**From:** [REDACTED]  
**Sent:** [REDACTED]  
**To:** [REDACTED]  
**Subject:** Re: Request for further information AW/3/21/HH  
**Attachments:** We sent you safe versions of your files; D.1062H-03A - Proposed Plans.pdf; 4 Shorecroft - Flood Risk Assessment.pdf

F.A.O Iqraa Malik

Drawing No. C.1062H - 03
Date: 22-12-20

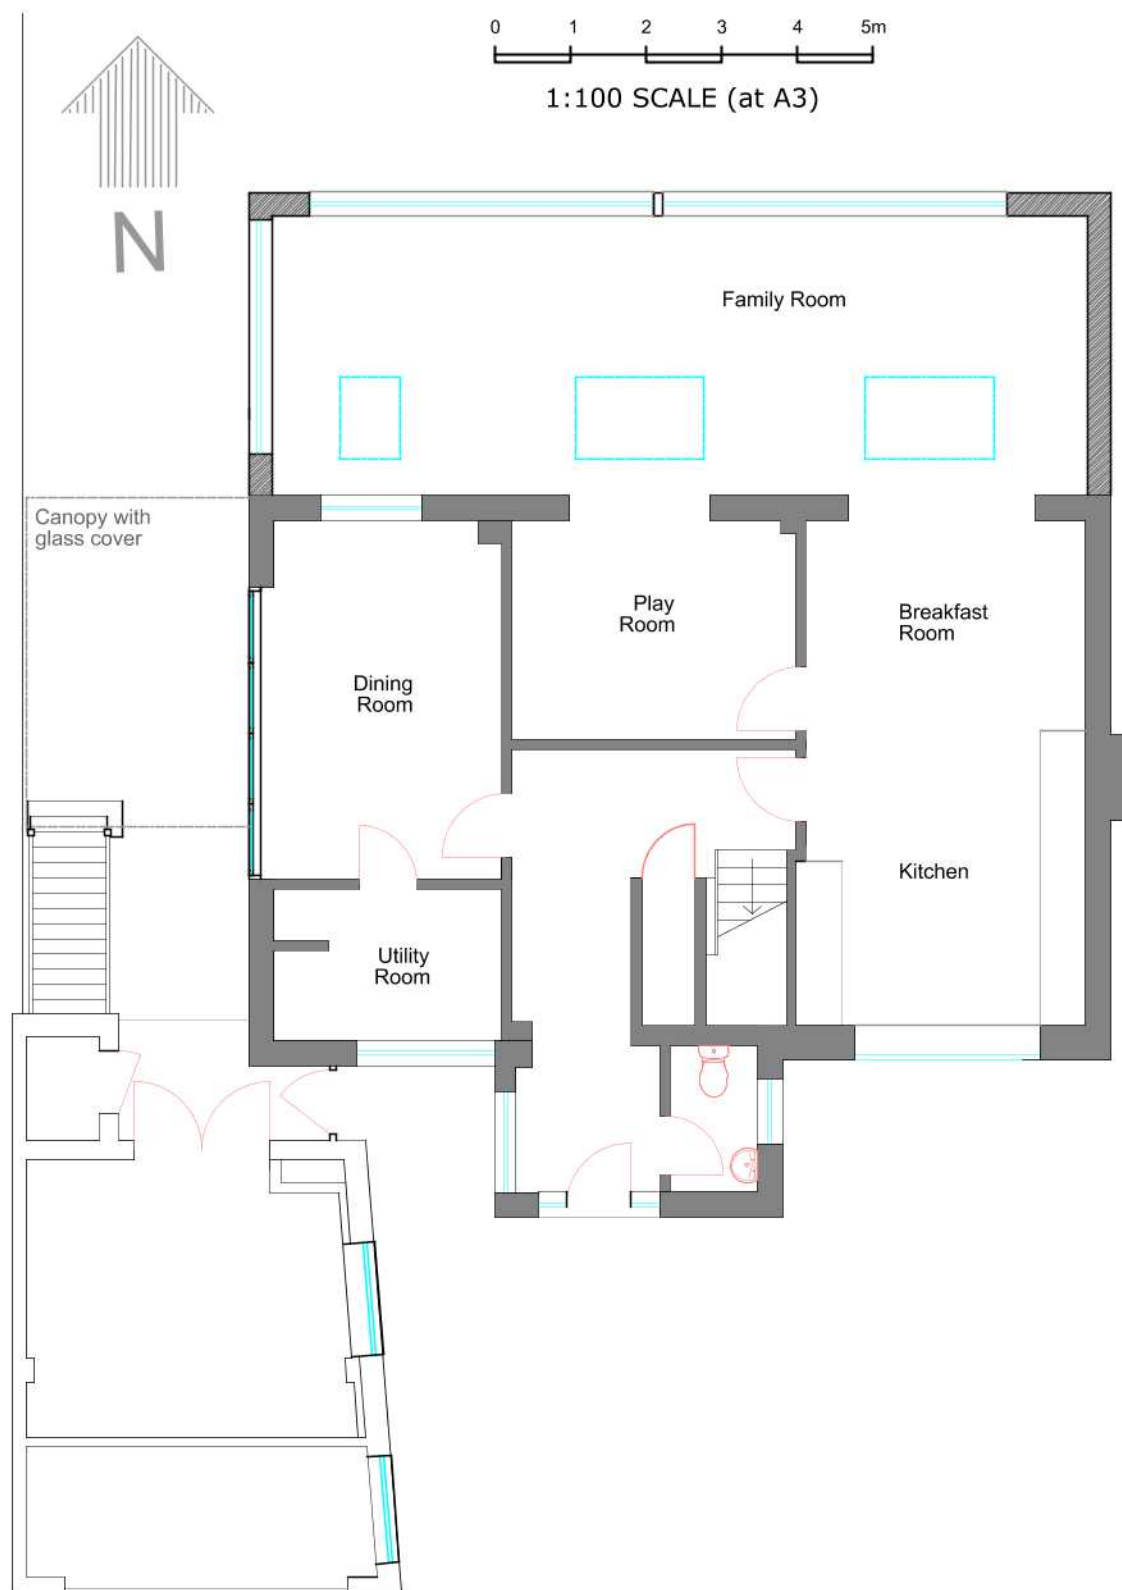
1) The window displayed on the east elevation isn't shown on the floor plan.  
Please find amended
